Department of Industry

OUT17/41238

**Woodlawn Bioreactor (MP 10_0012 MOD 2 & DA 31-02-99 MOD 3)
Comment on the Response to Submissions (RTS)**

Figure 2 – Woodlawn ED3 North system

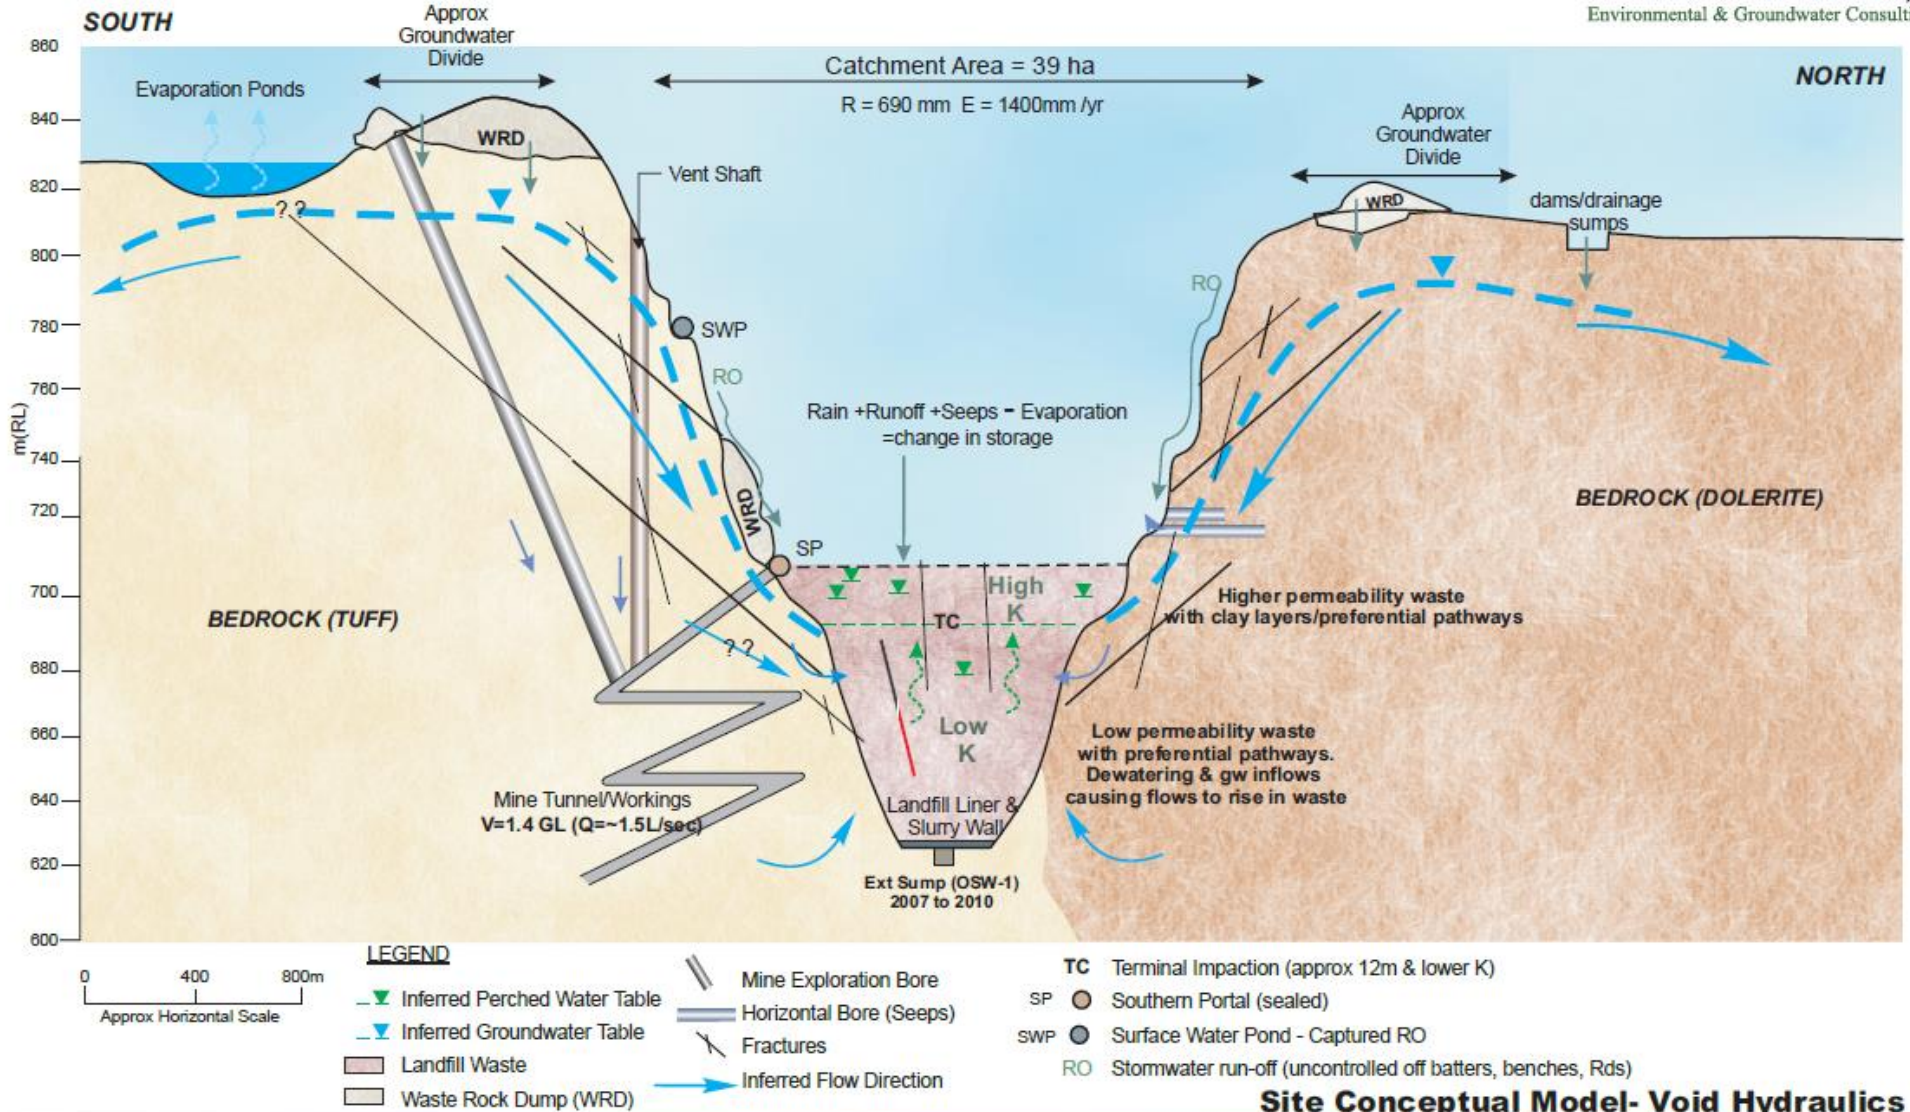
- The proponent should be required to use only high-density polyethylene lining specification as recommended by AECOM (the specialist consultant) for lining the evaporation dams..
